ELLICOTT TOWN CENTER

Filing No. 1

Grading & Erosion Control Plans

El Paso County, Colorado

SHEET:
C1.02

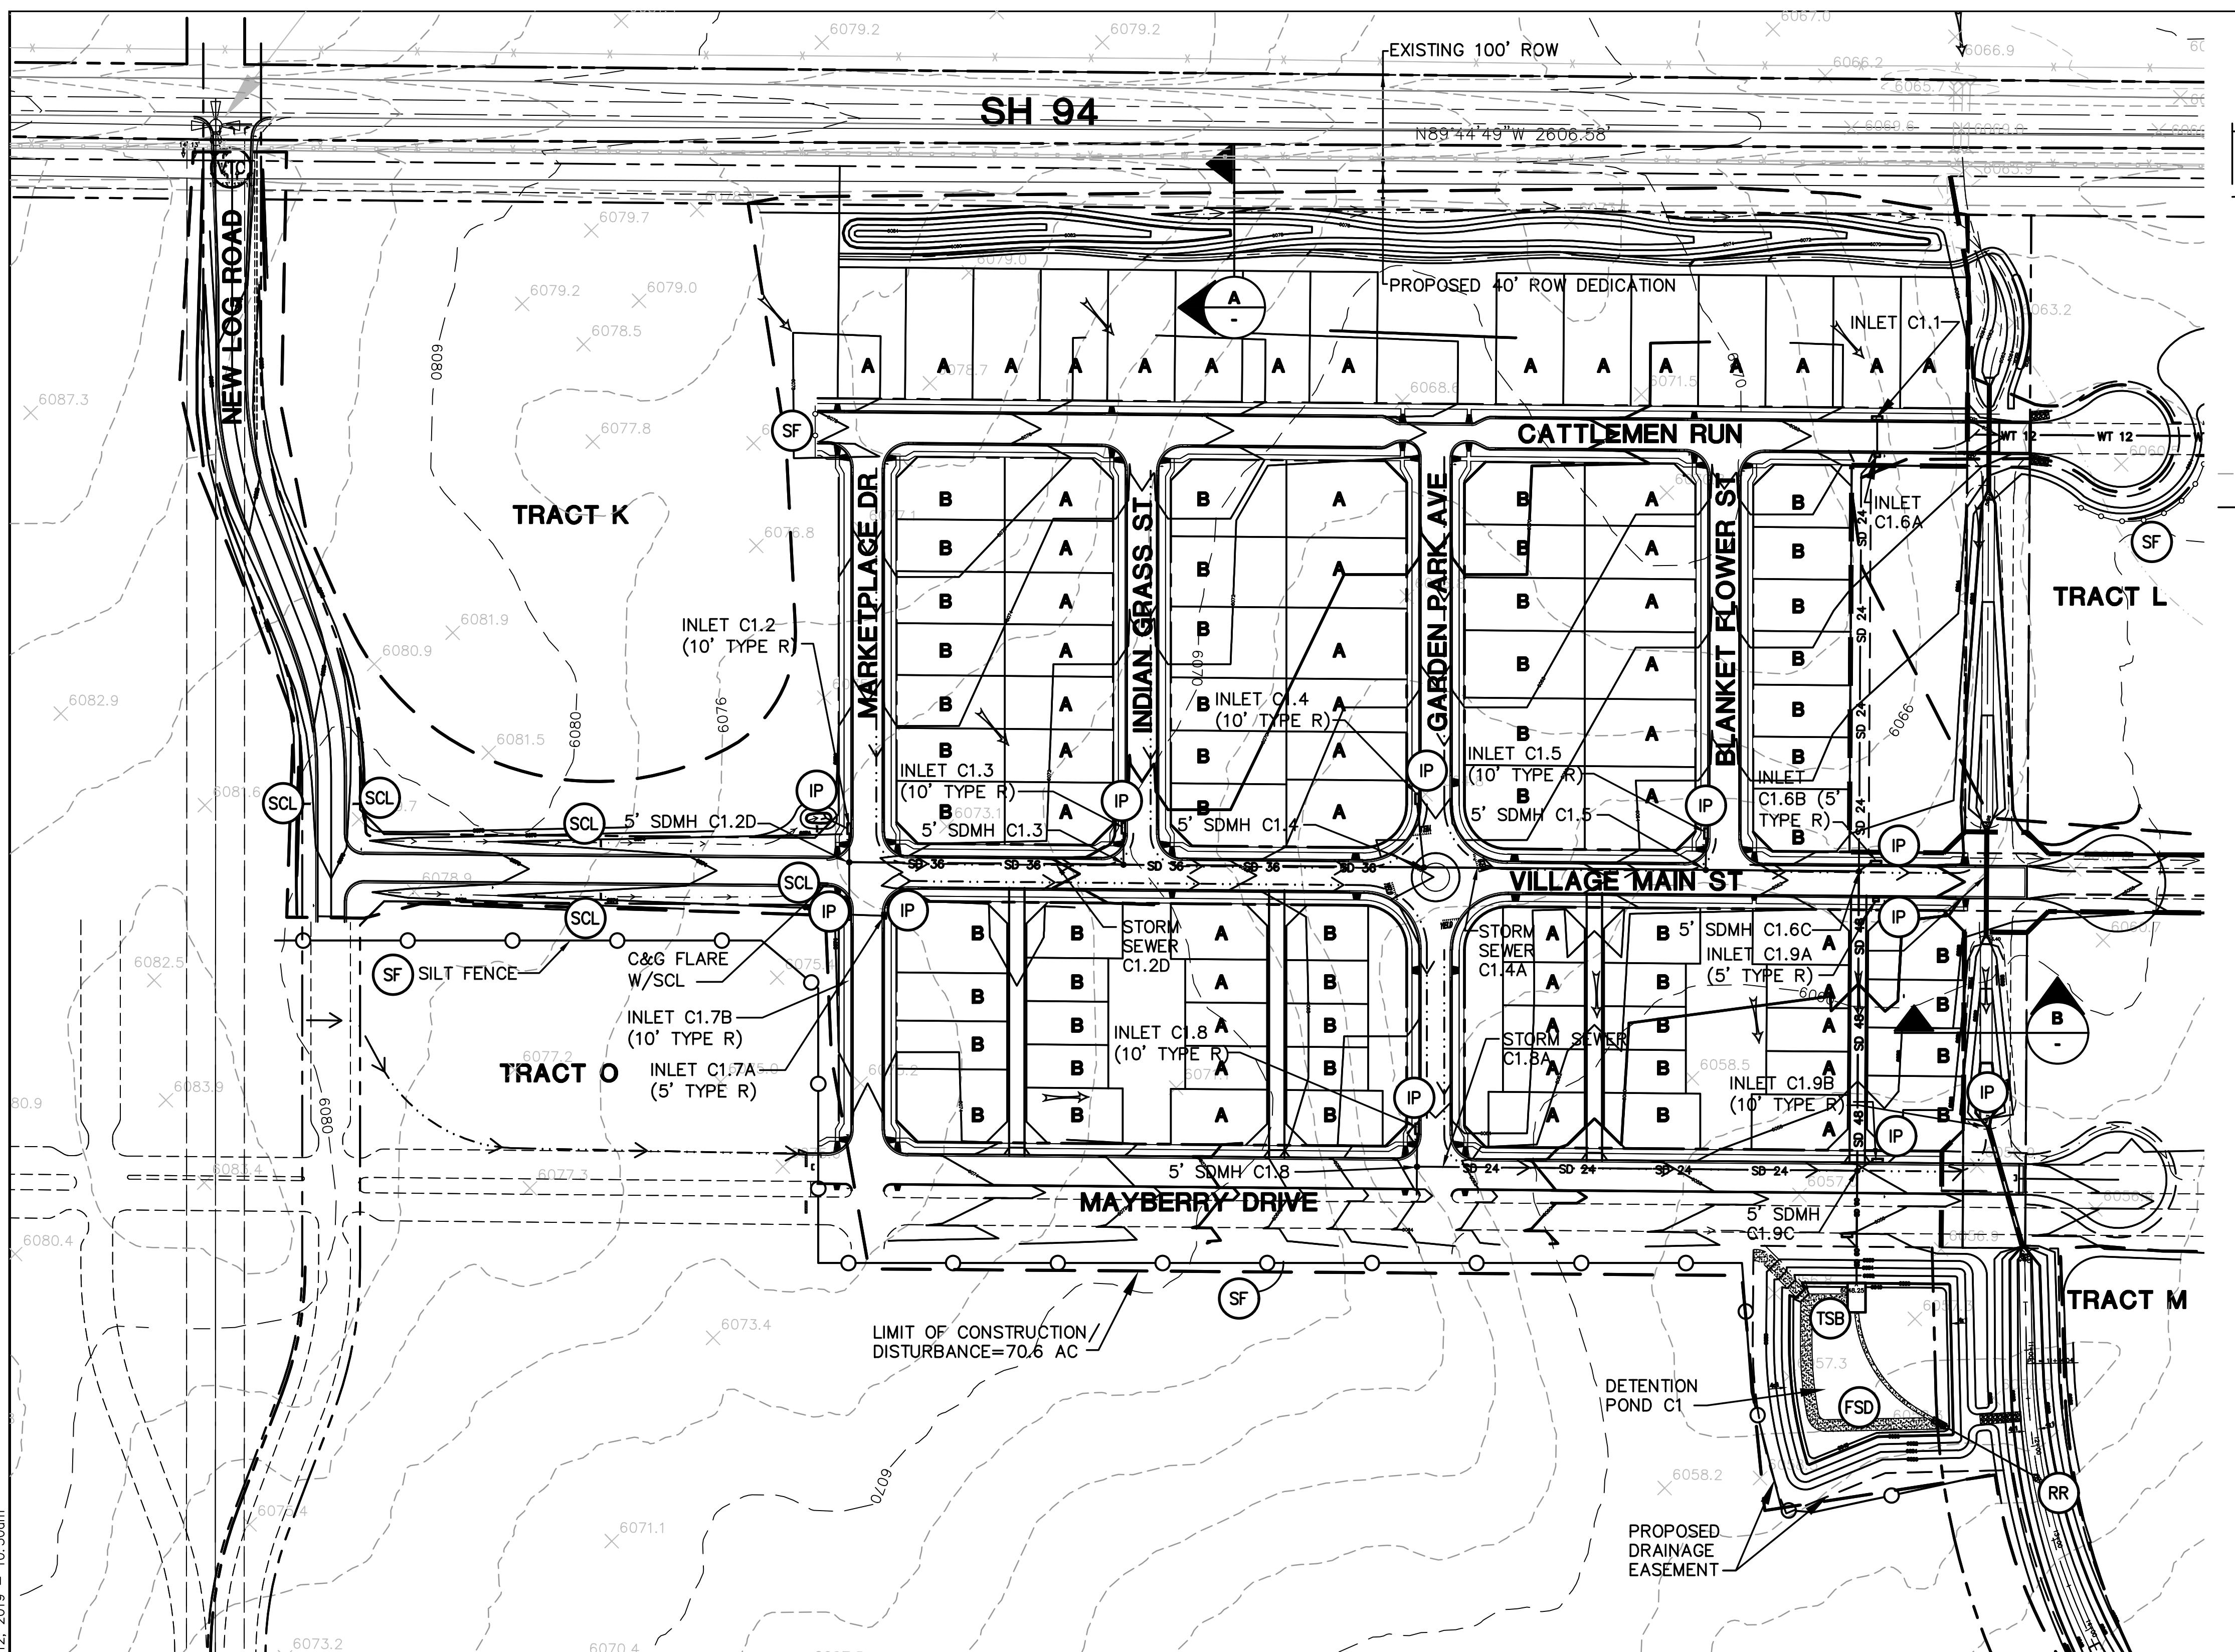
Show limits of construction/disturbance.
Show and label TSBs.
See checklist.

SHEET: C1.03

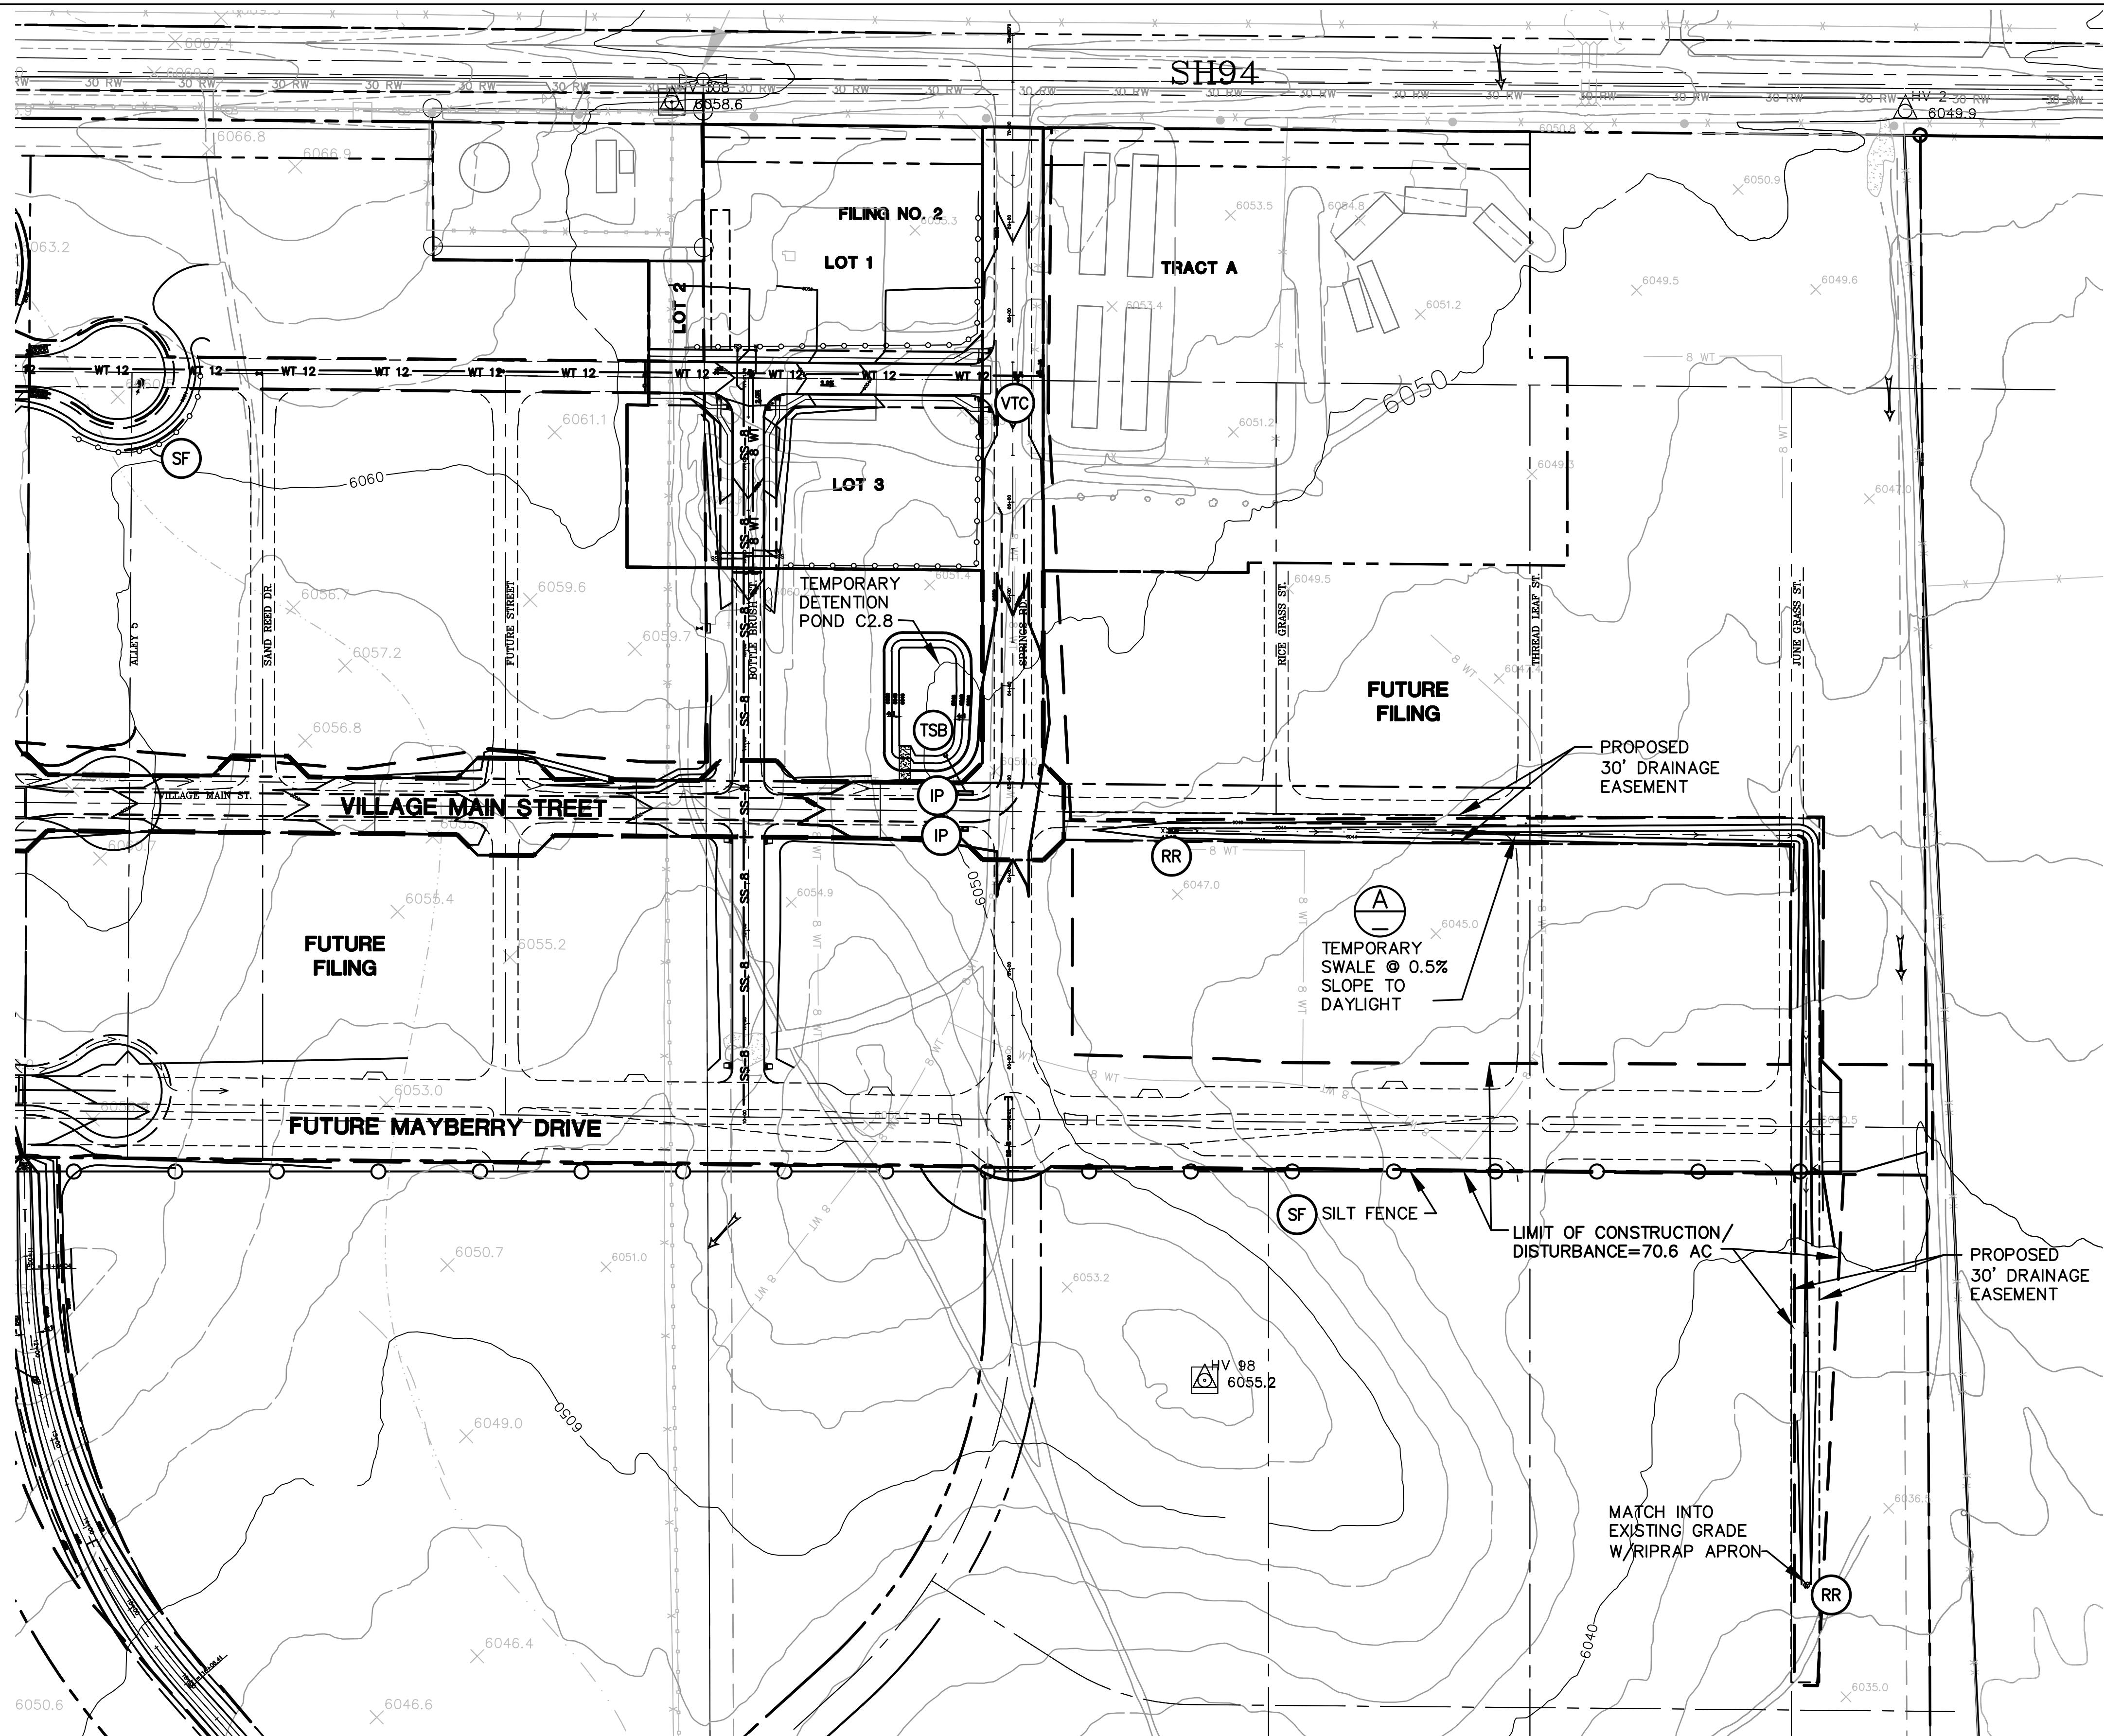
Provide project limits and limits of construction
